A1 in Northumberland: Morpeth to Ellingham

Scheme Number: TR010059

Summary of Proposed Changes to Application

December 2020

Key

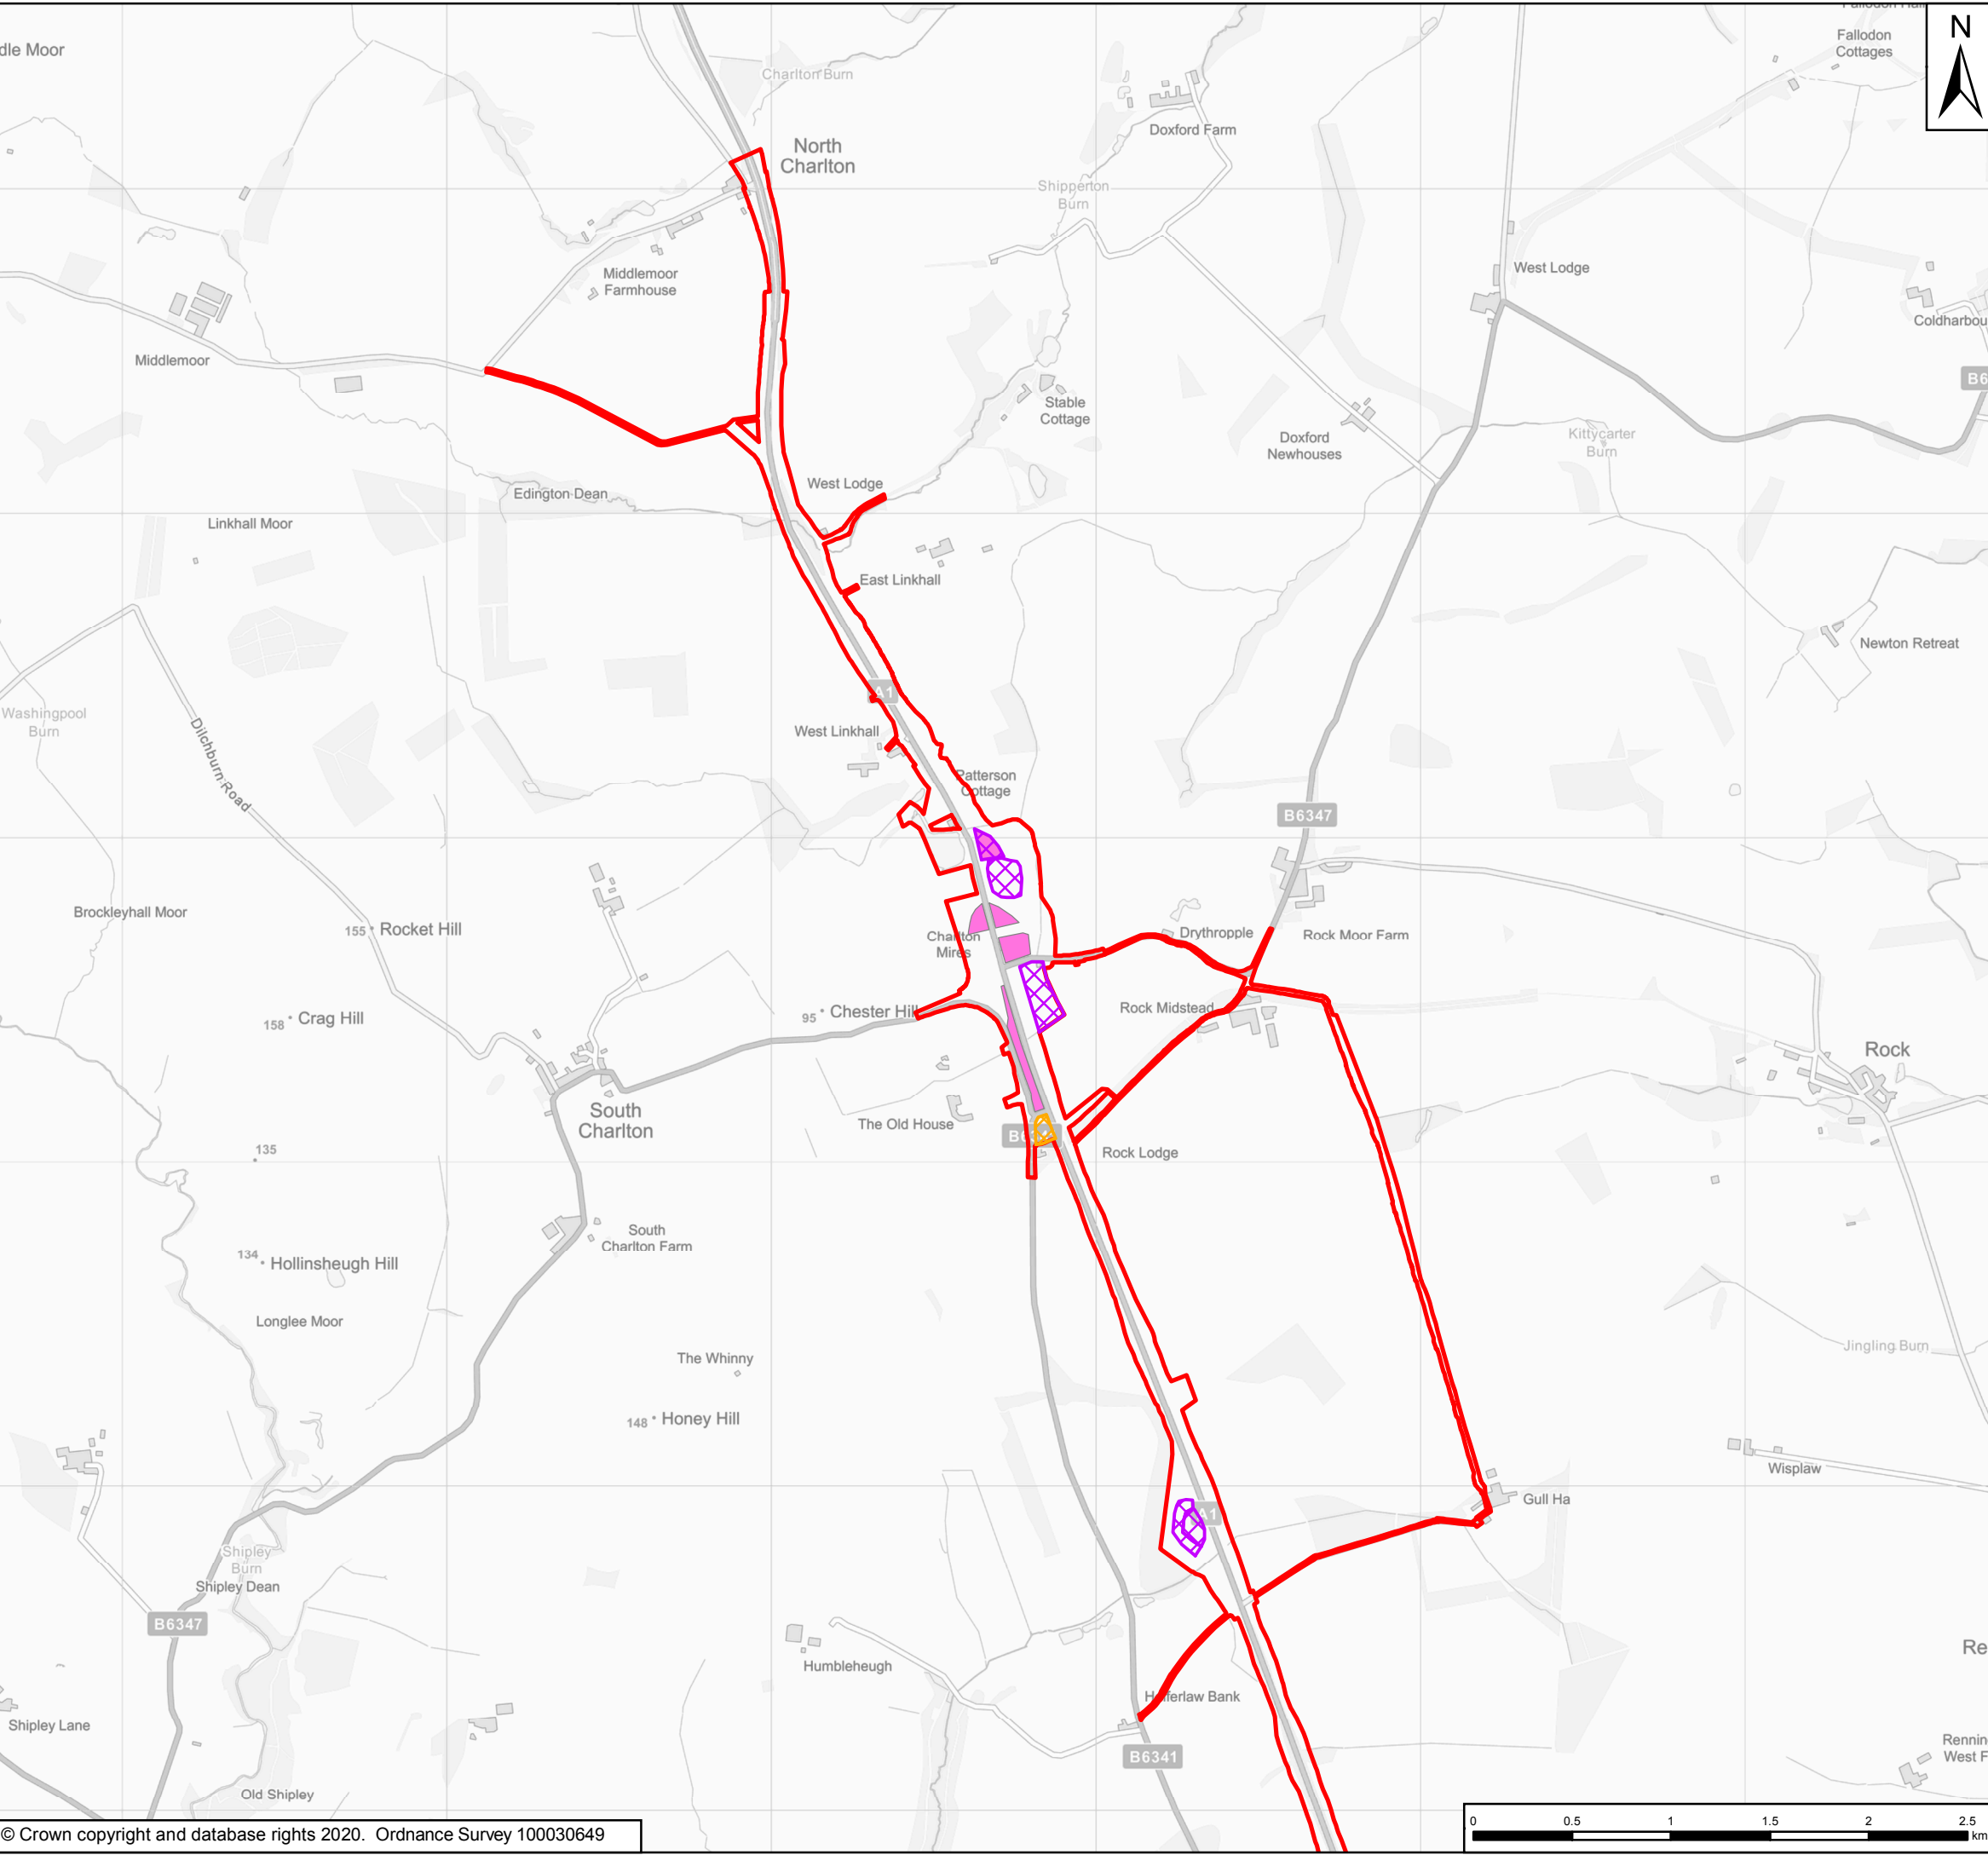
- 2.1.1 The Applicant proposes to maximise the re-use of materials (via excavation, deposition and temporary storage), within the existing Scheme extents. A recent review of the earthworks strategy has identified an opportunity to reduce earthwork movement and as a result greater flexibility in temporary and permanent storage of Site won material is required to achieve this. The indicative earthworks areas are shown in the figure in the **Indicative Earthwork Change Locations** figure in **Appendix A**.

- 2.1.2 To balance materials across both Parts A and B, the following methods are proposed:
- Utilising borrow pits to exchange and win additional material suitable for construction.

- Creation of new soil bunds within Part B to maximise re-use of excess site material.
 - Maximising of slopes for re-use of excess site material, in Part B.

- Laying down additional material increasing some localised ground levels.
 - Raising levels of junction “bowls” (level or rounded rather than dished).

- Creating new, temporary soil storage areas within both Part A and Part B.
- 2.1.3 These changes are an alteration to Parameters 4 and 5 for Part A, as set out in **Chapter 2: The Scheme** of the ES [APP-037]. There would also be additional temporary and permanent earthworks that require assessment for Part A and Part B. Therefore, it is appropriate to ensure that the environmental information before the Examination addresses the prospect of altered impacts This is addressed by sensitivity testing as described at **paragraph 2.1.6** below.

Temporary Works at the River Coquet

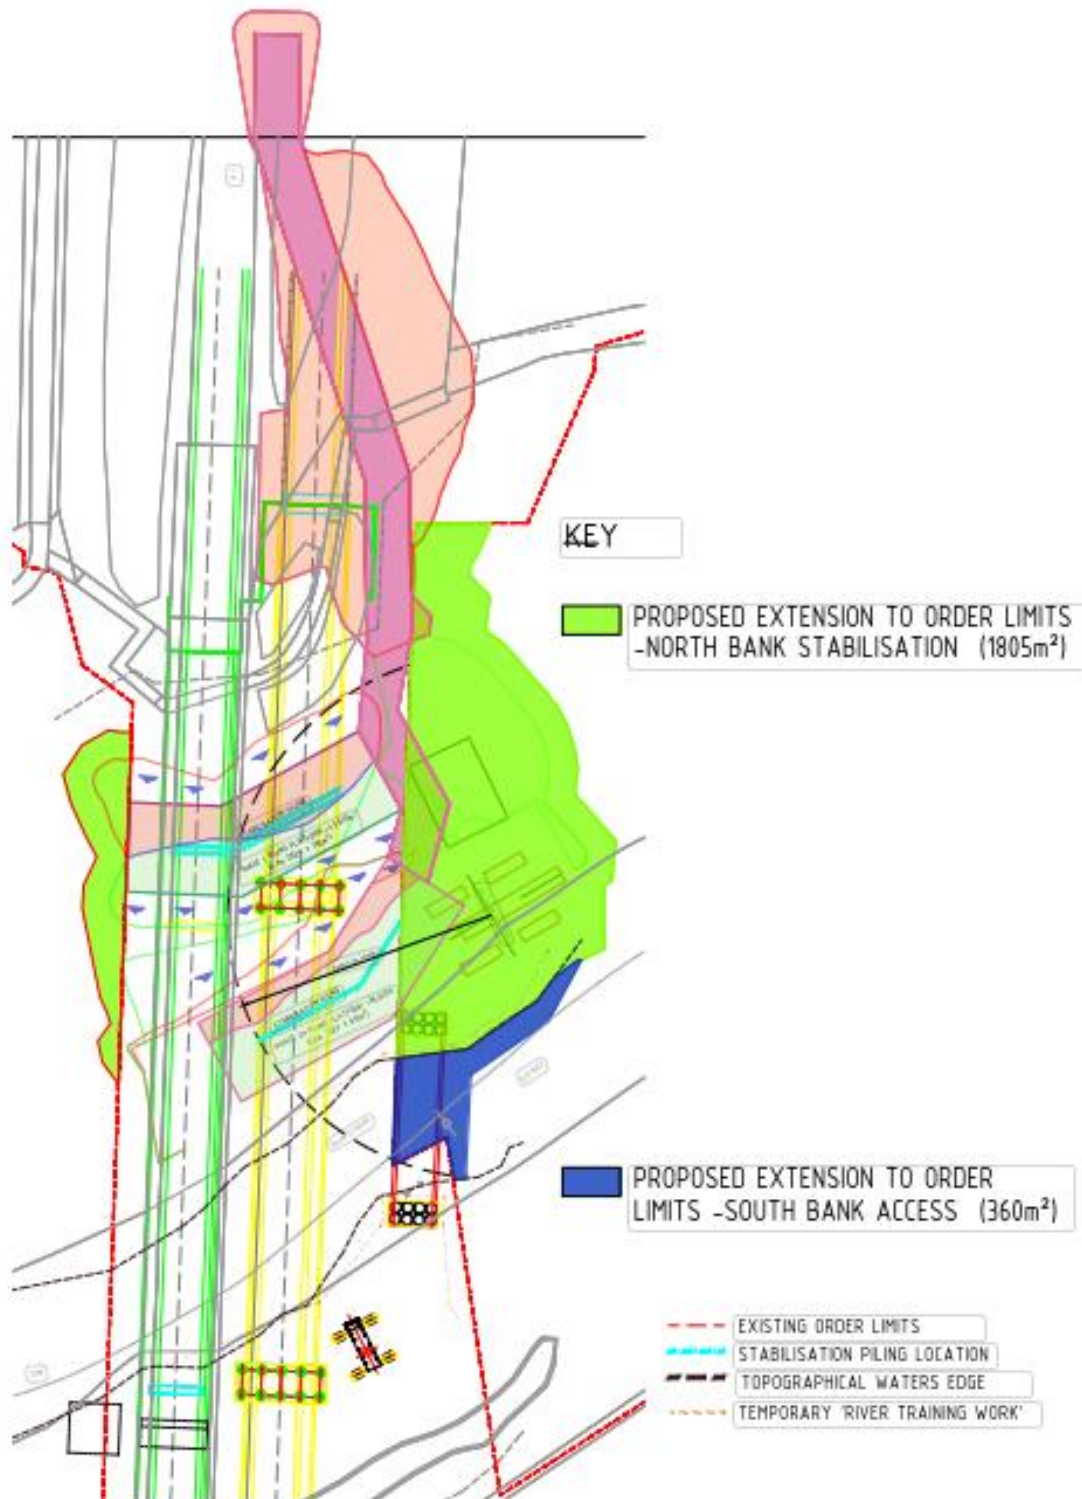
- 2. Works on the north bank of the River Coquet in order to stabilise the proposed bridge and existing bridge within Part A. The stabilisation works would include the installation of piles in the north bank of the River Coquet and the installation of erosion protection measures on the river bank. Land outside the Order limits would temporarily be required as a working area for the installation of the piles and access to works, as well as for the carrying out of the erosion protection

3. Provision of a temporary access to the south bank of the River Coquet is proposed by crossing the river from the temporary works on the northern bank. It is anticipated that this would result in improved environmental performance in terms of access that would otherwise be provided from the South bank itself. The engineering solution for such a crossing is to use of a temporary bridge to span over the river. It is anticipated that there would also be some temporary river training works along each riverbank and additional erosion protection to the southern pier of the new bridge. Additional temporary rights would be required for the installation of the temporary bridge.

Permanent Works at the River Coquet

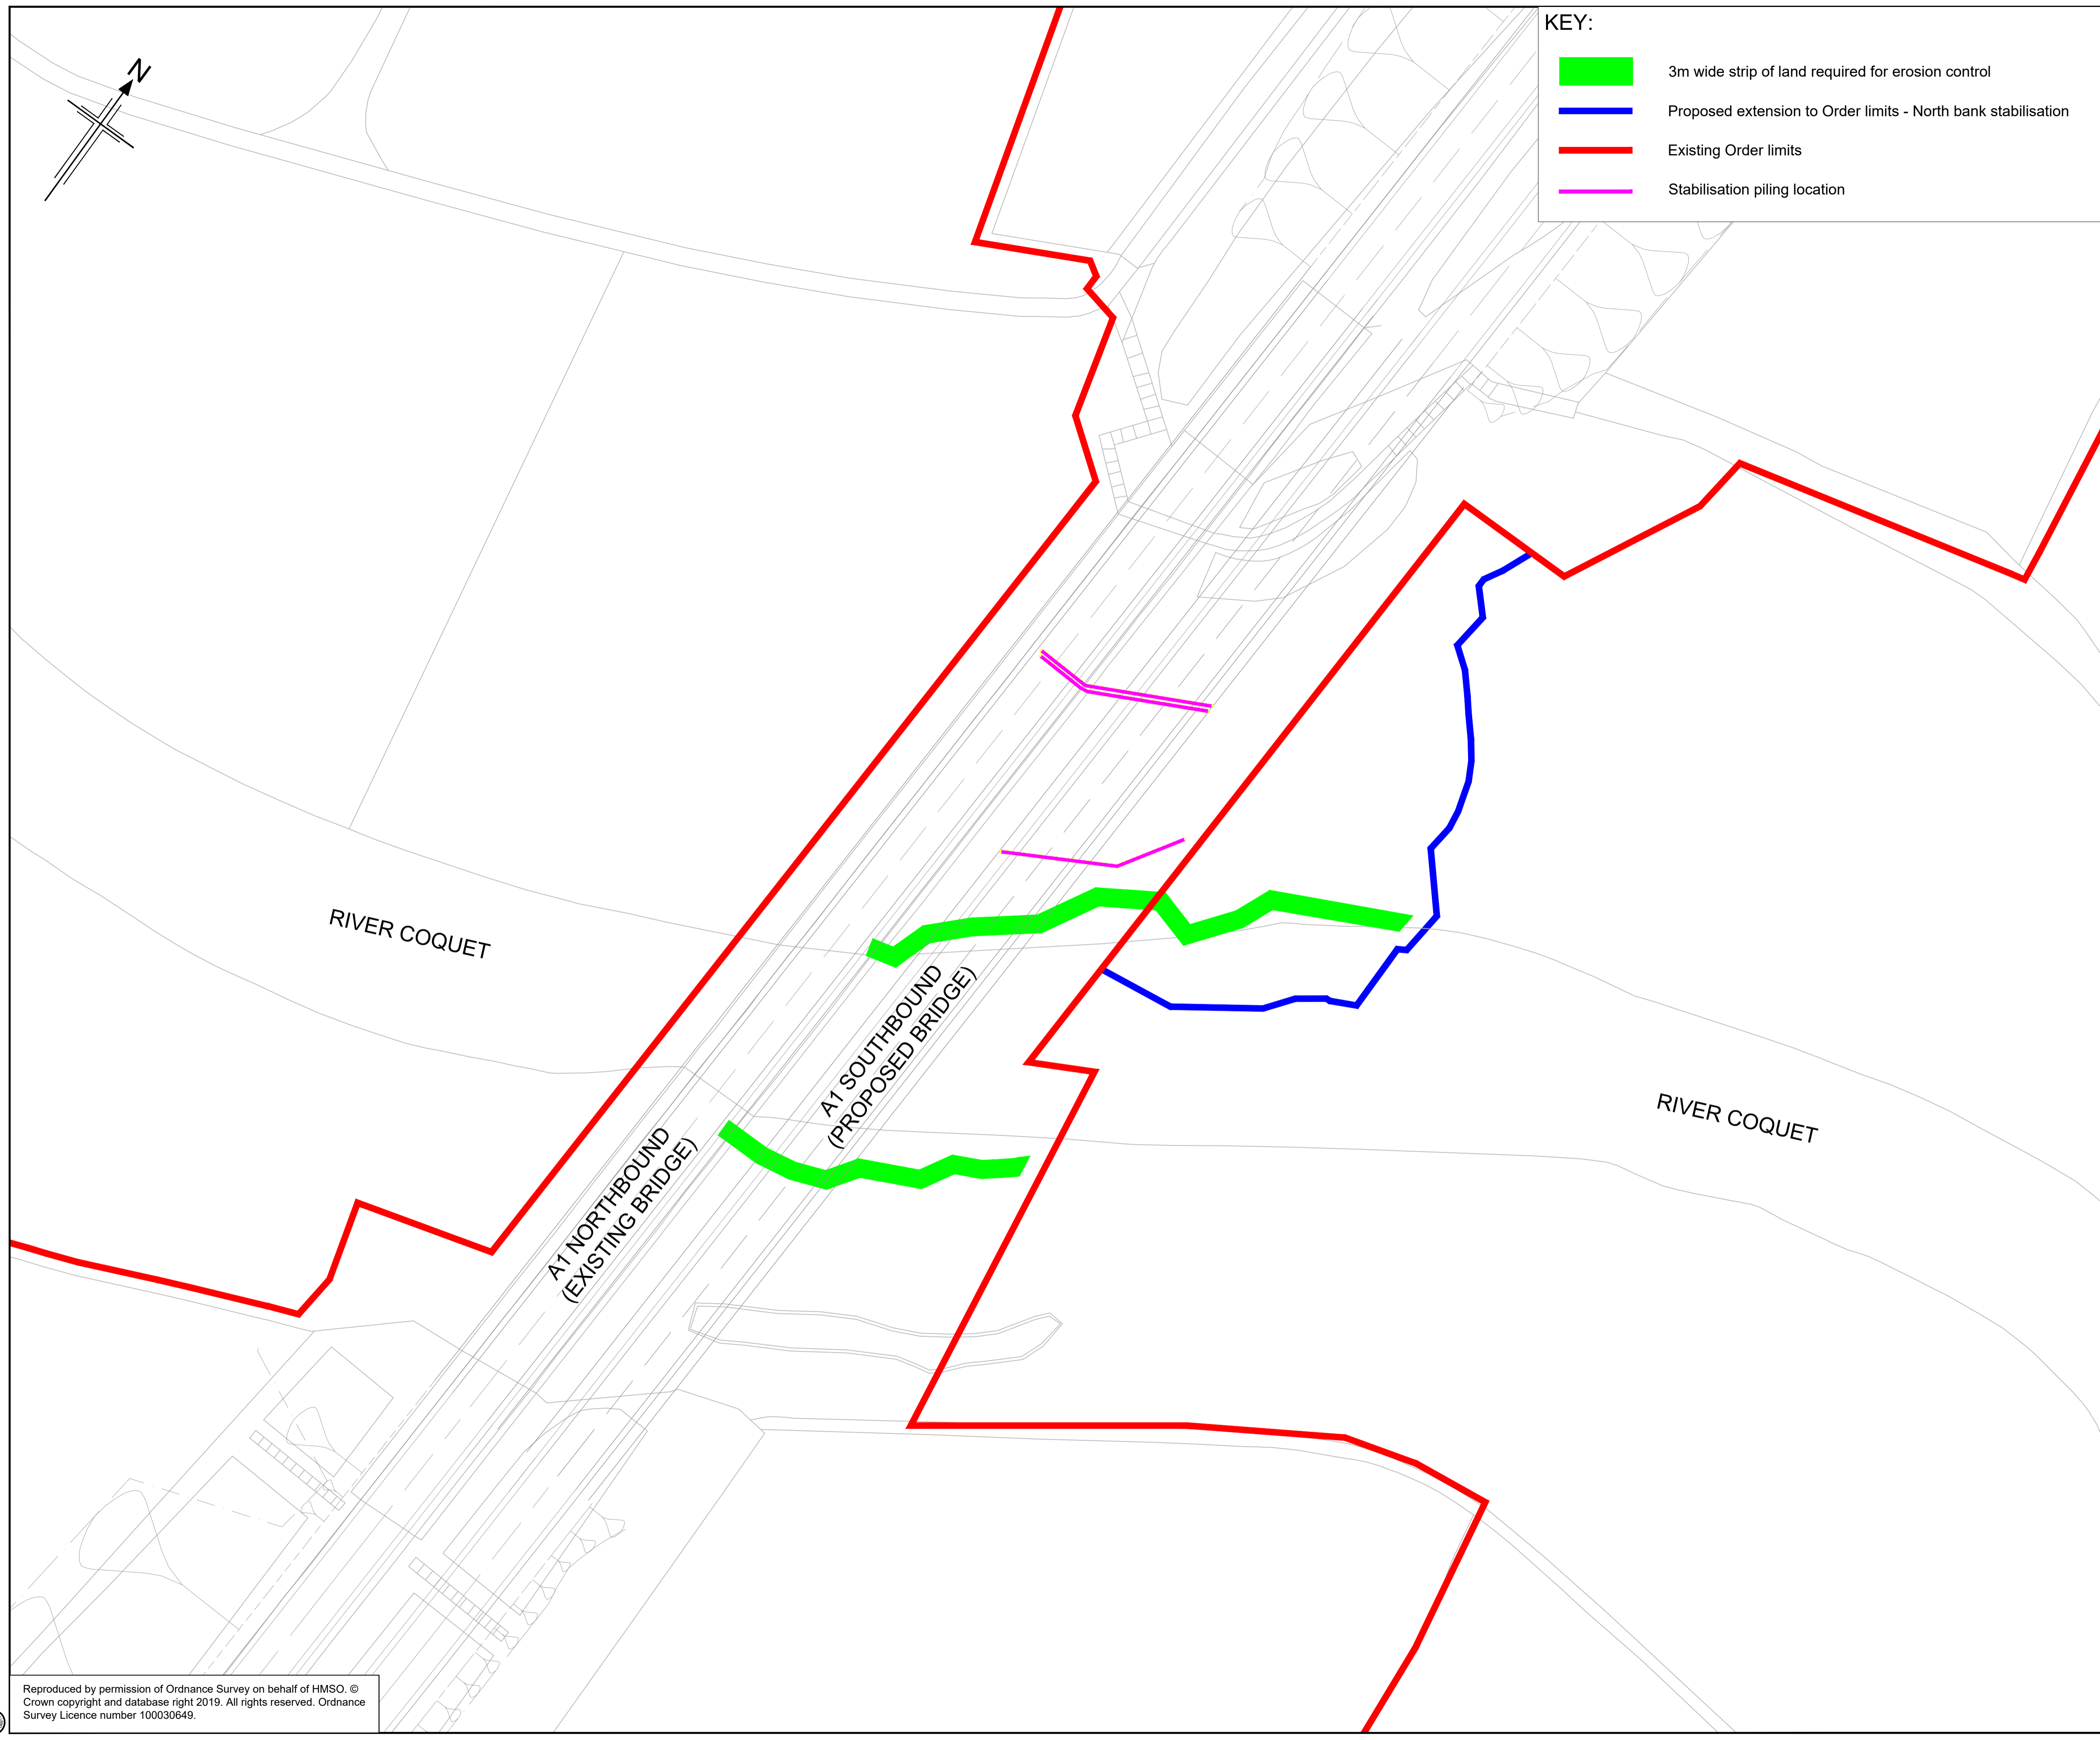
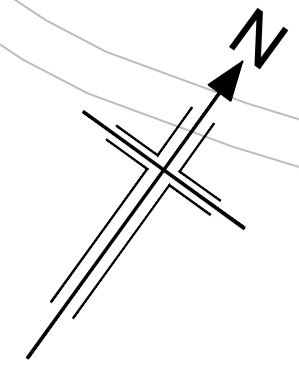
measures. As the installation works would lead to the loss of woodland within the Coquet River Felton Park Local Wildlife Site (LWS), there may also be a requirement for additional compensatory habitat outside the Order limits. Permanent erosion protection measures are proposed on the north bank (including outside the existing Order limits) and on the south bank.
